# CITY OF ALBUQUERQUE

November 4, 2019

**Re: Albuquerque Healthcare for the homeless**  
**121 Mountain Rd. NW**  
**Traffic Circulation Layout**  
Engineer's/Architect's Stamp 10-14-2019 (J14D050)

TRAFFIC CIRCULATION LAYOUT PLAN

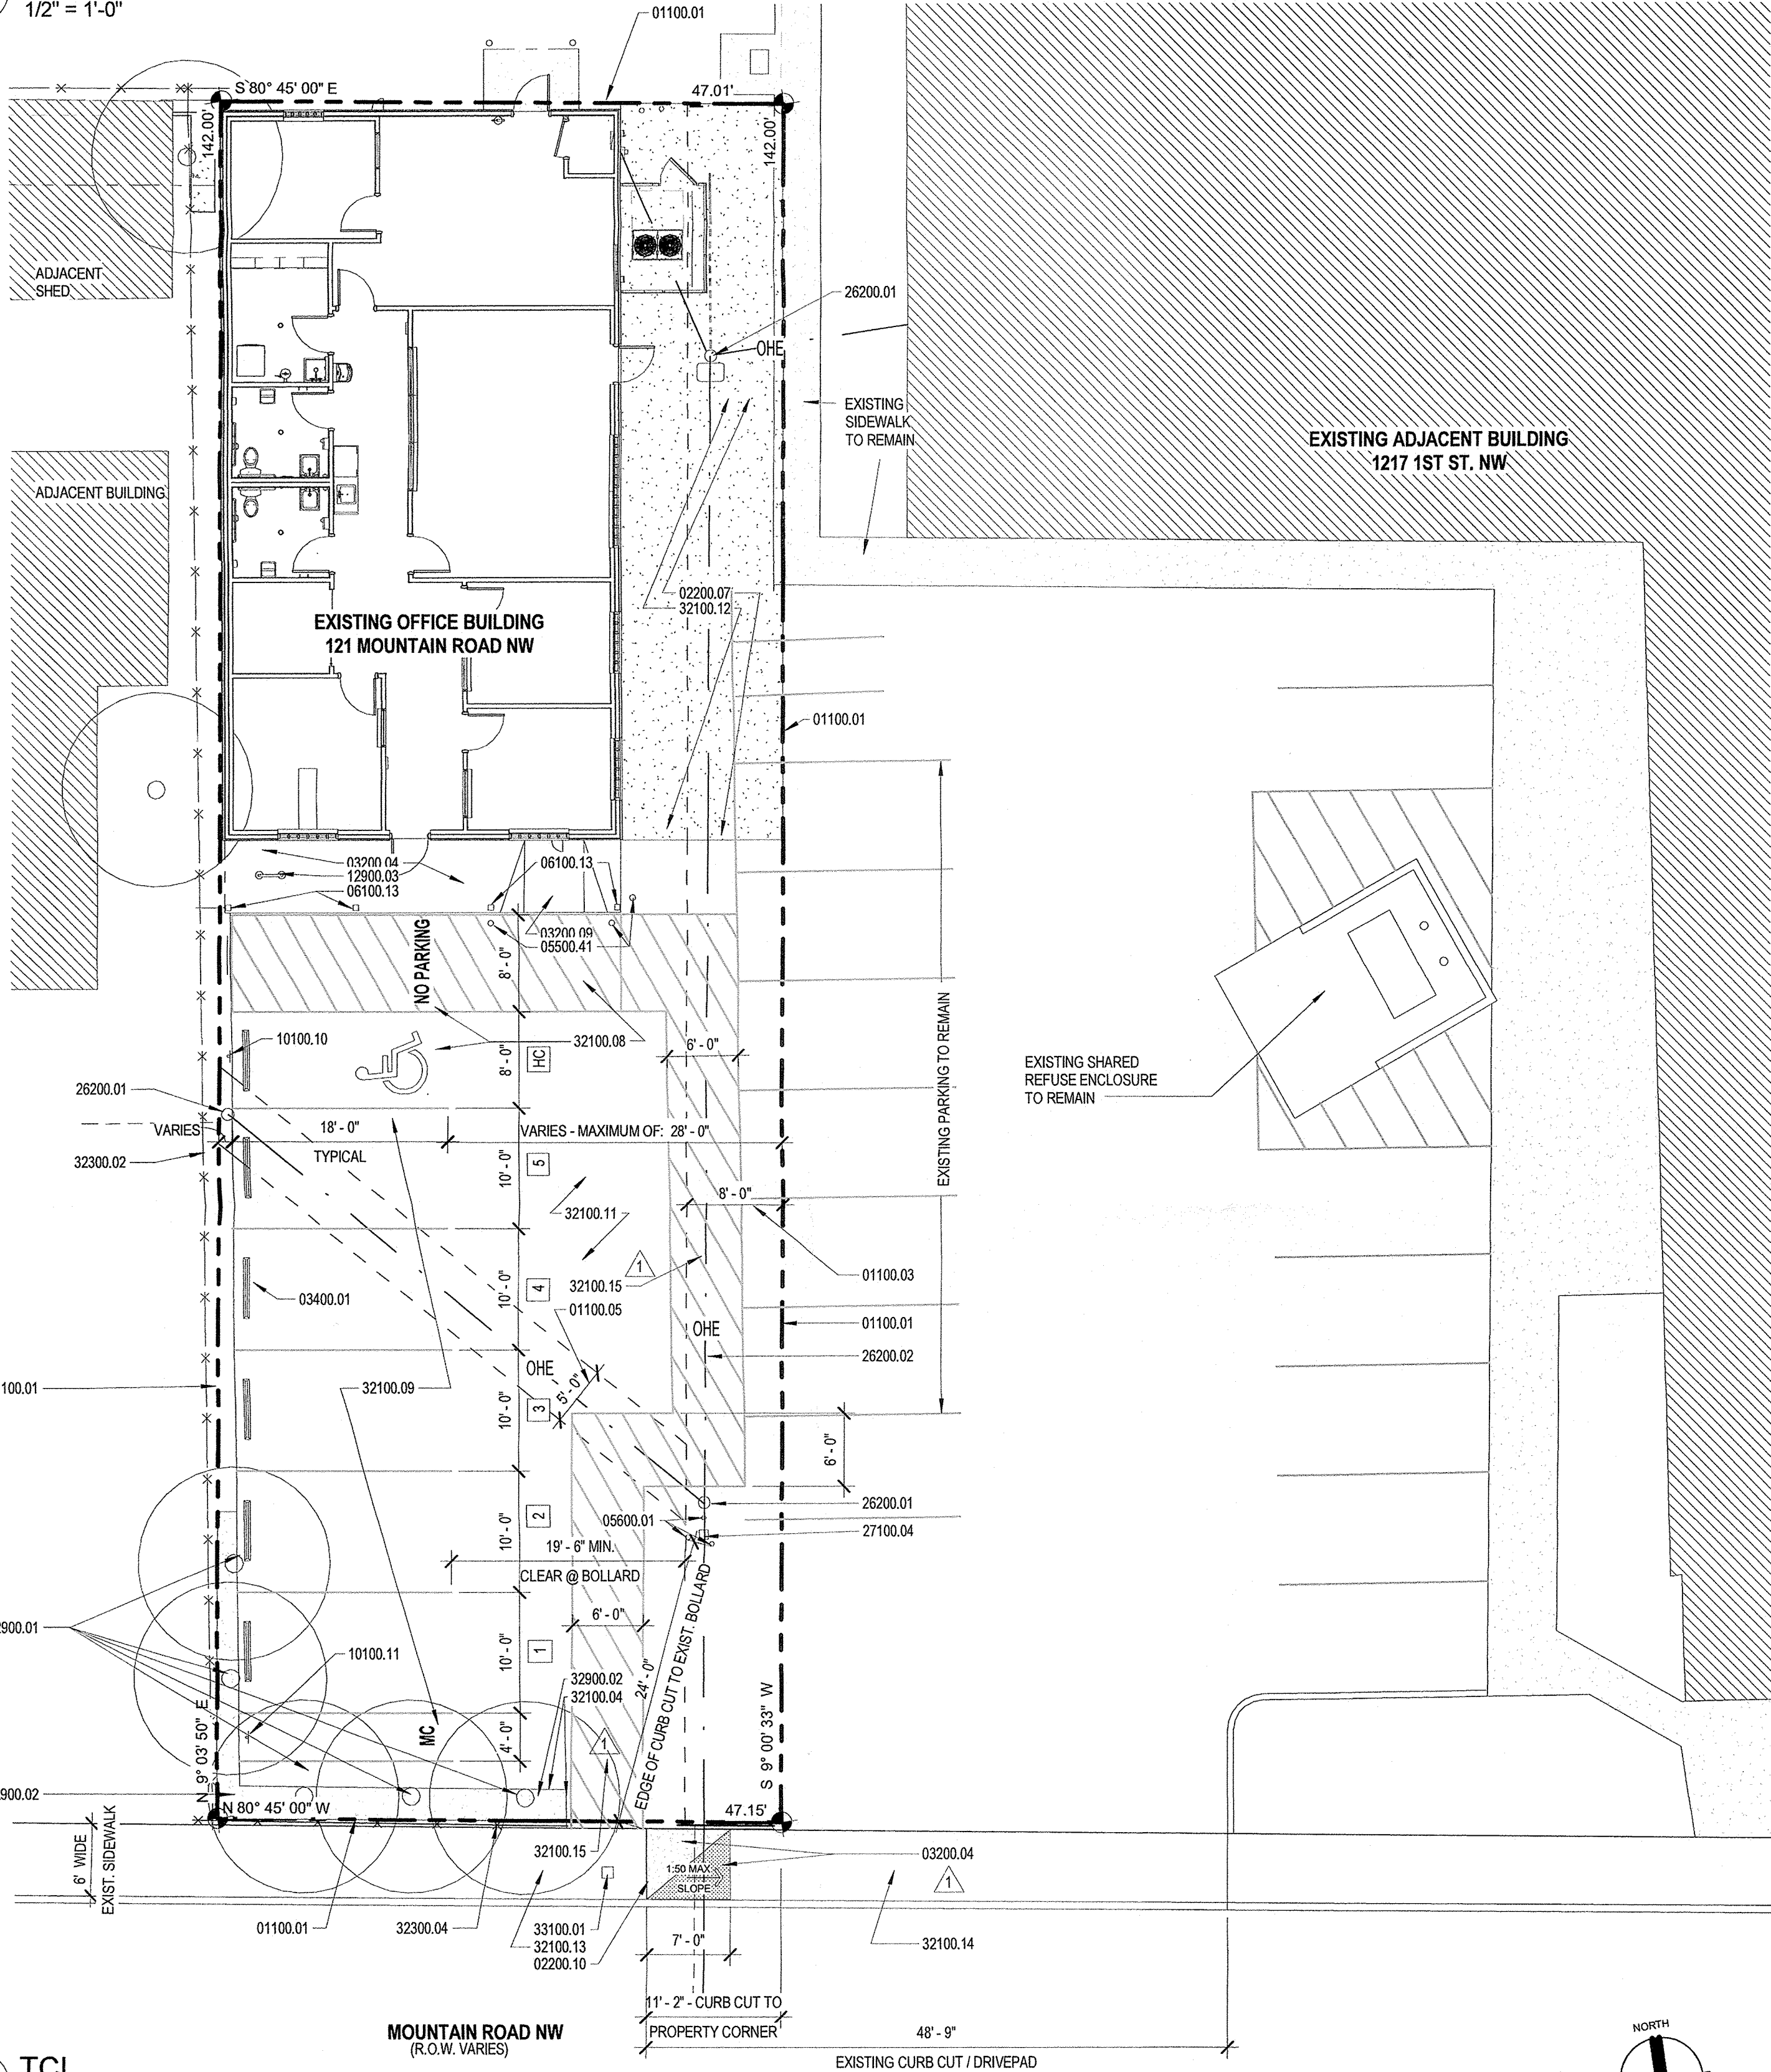
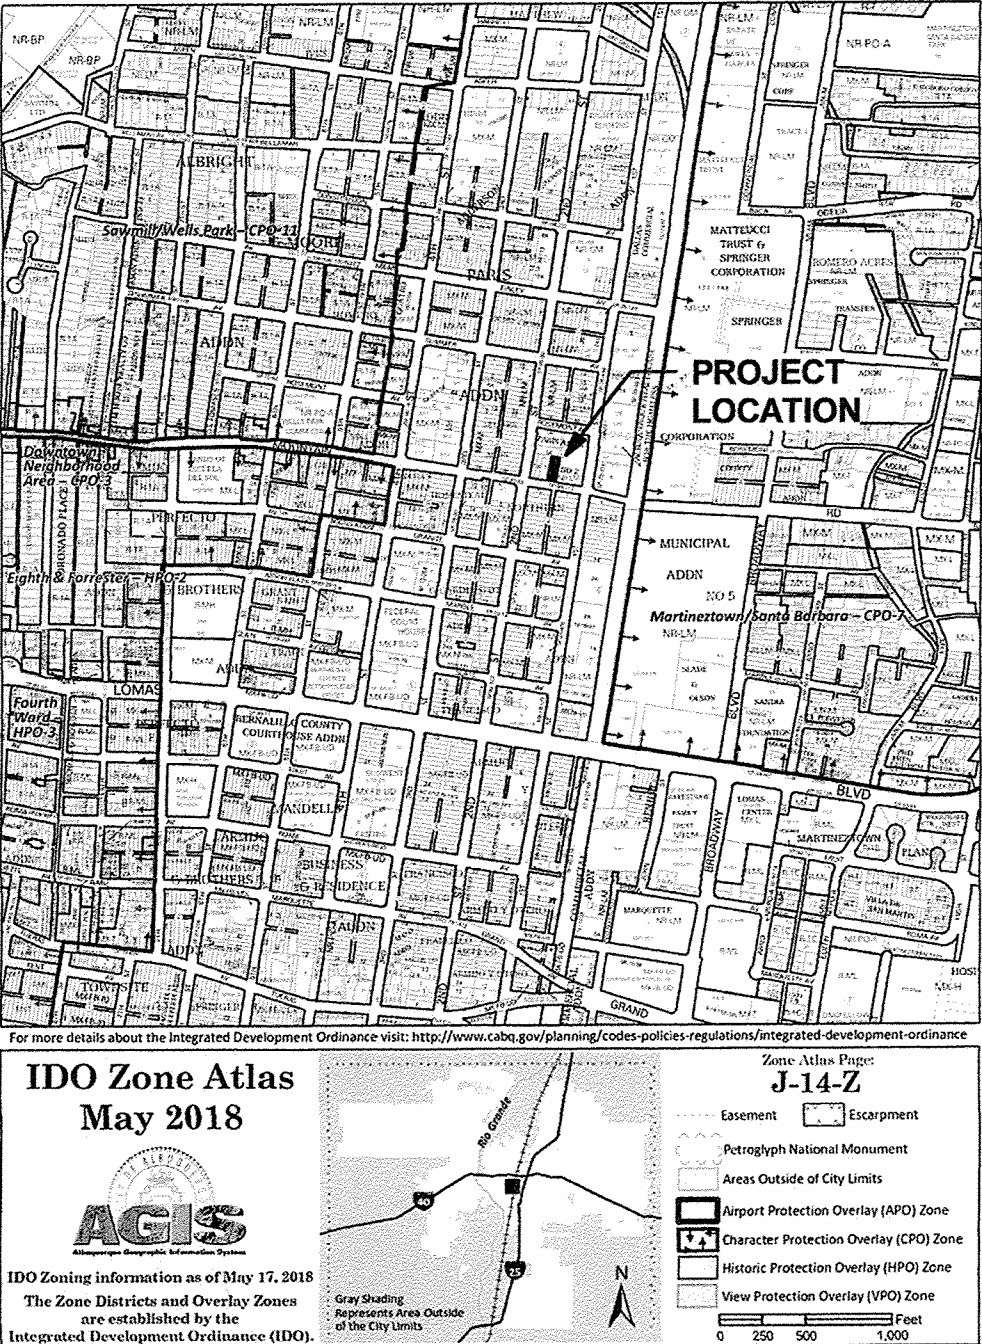
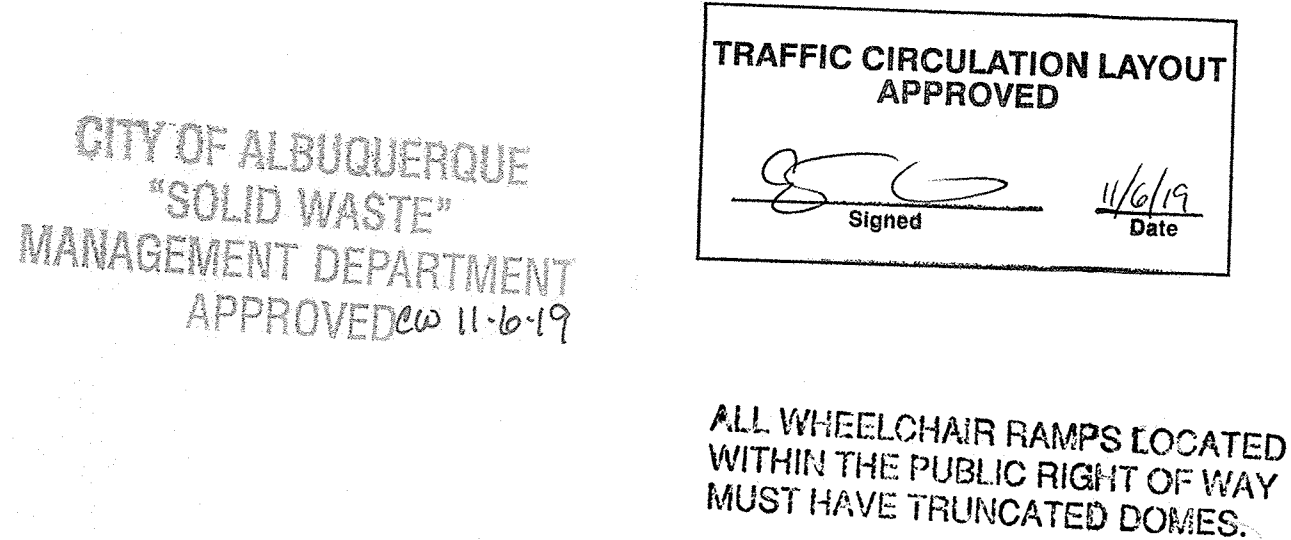
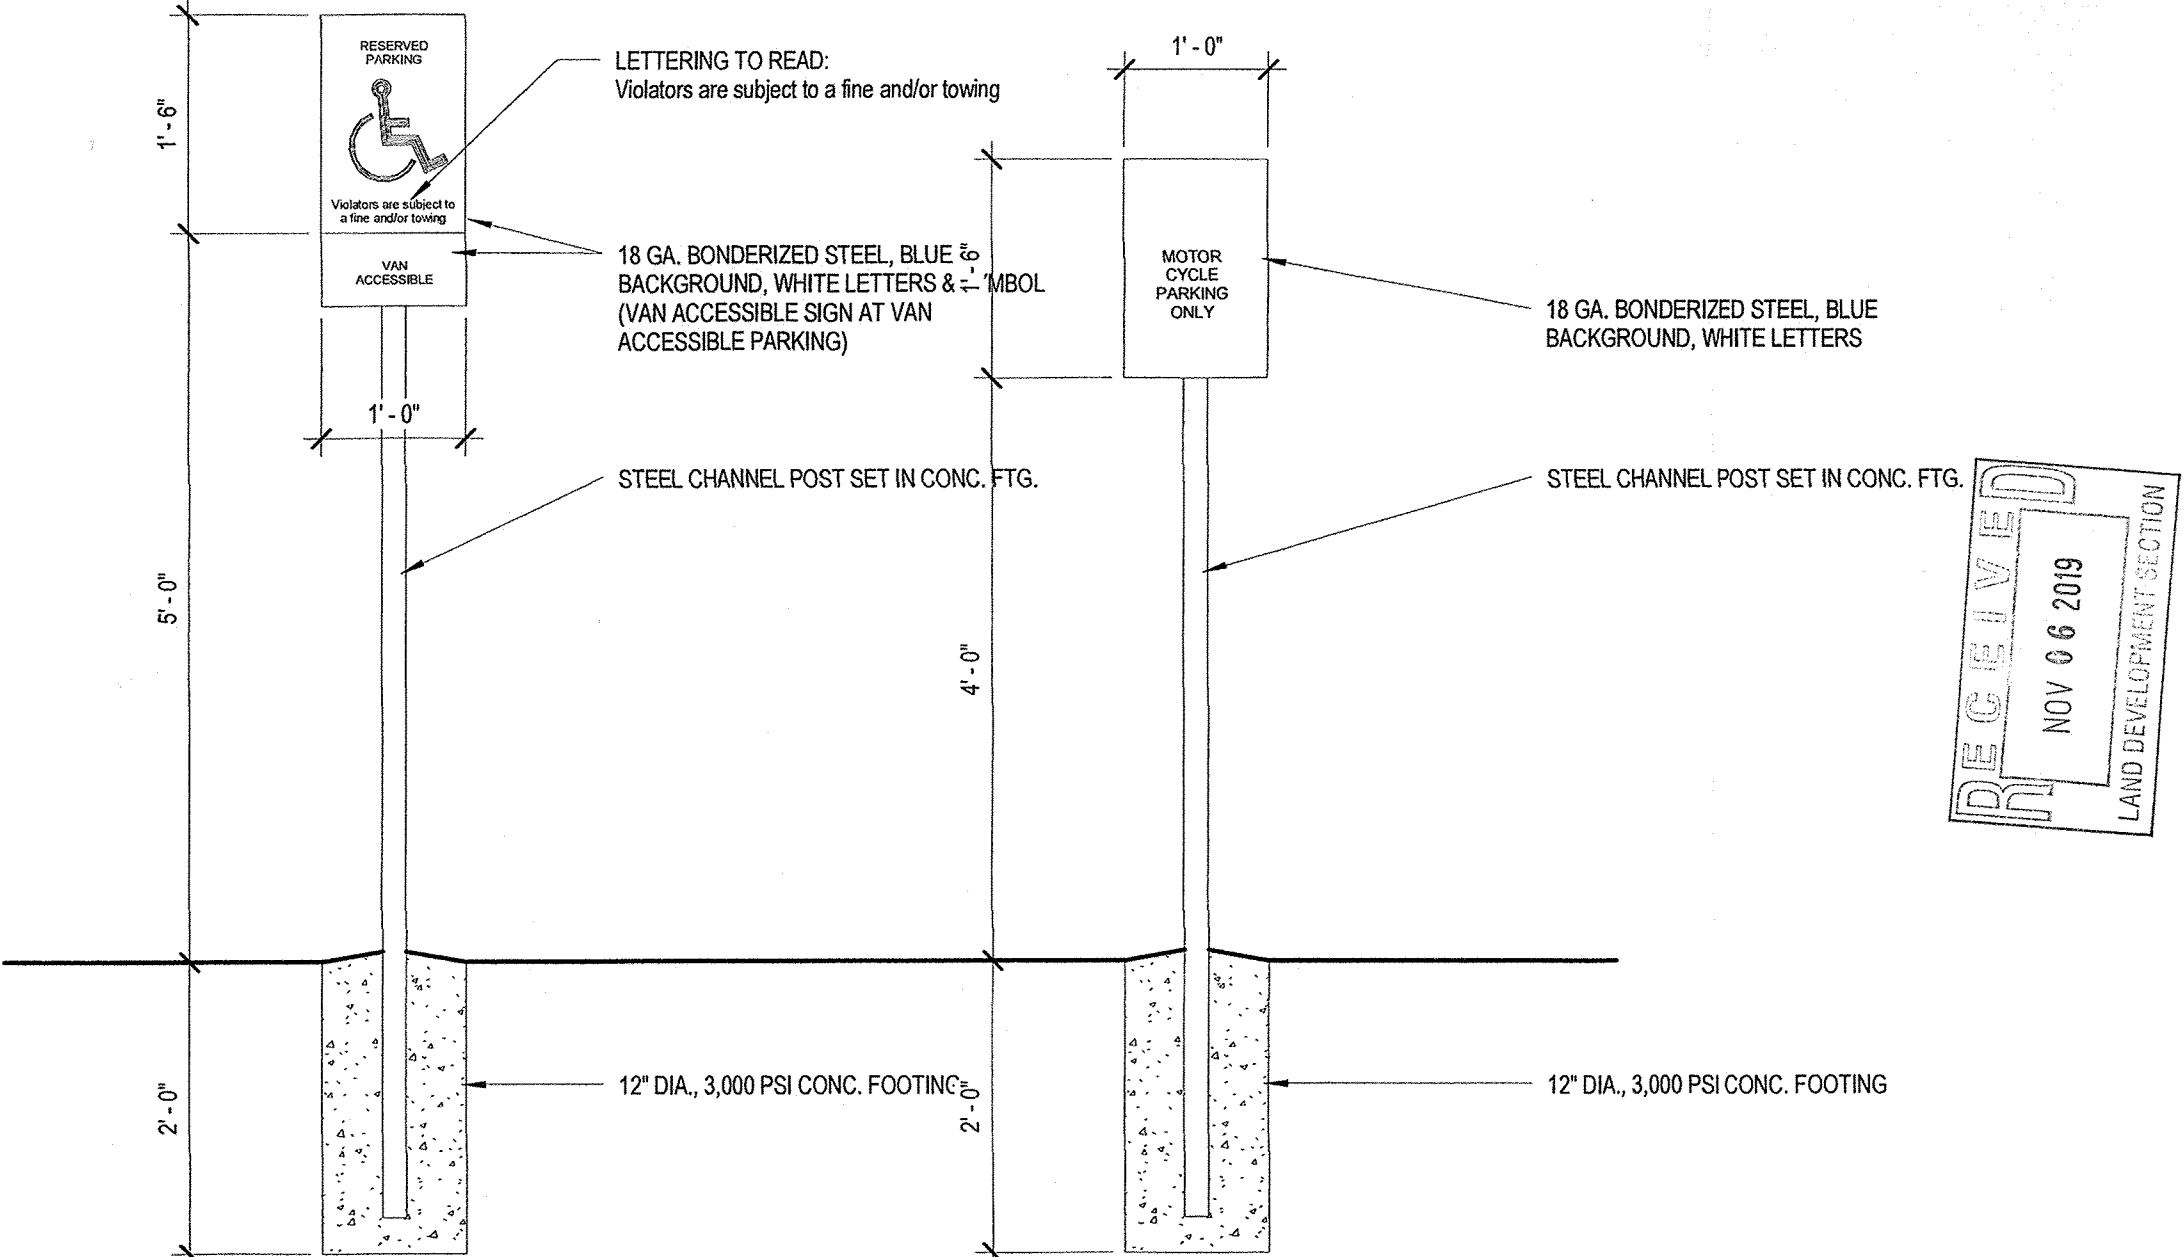
1. Provide a document showing a shared access agreement for the existing curb-cut.
2. ADA curb ramps must be updated to current standards and have truncated domes installed.
3. Per the IDO, a 6 ft. wide ADA accessible pedestrian pathway is required from the public sidewalk to the building entrances. Please clearly show this pathway and provide details.
4. Refuse vehicle maneuvering shall be contained on-site. The refuse vehicle shall not back into the public right of way.; **provide a copy of refuse approval.**
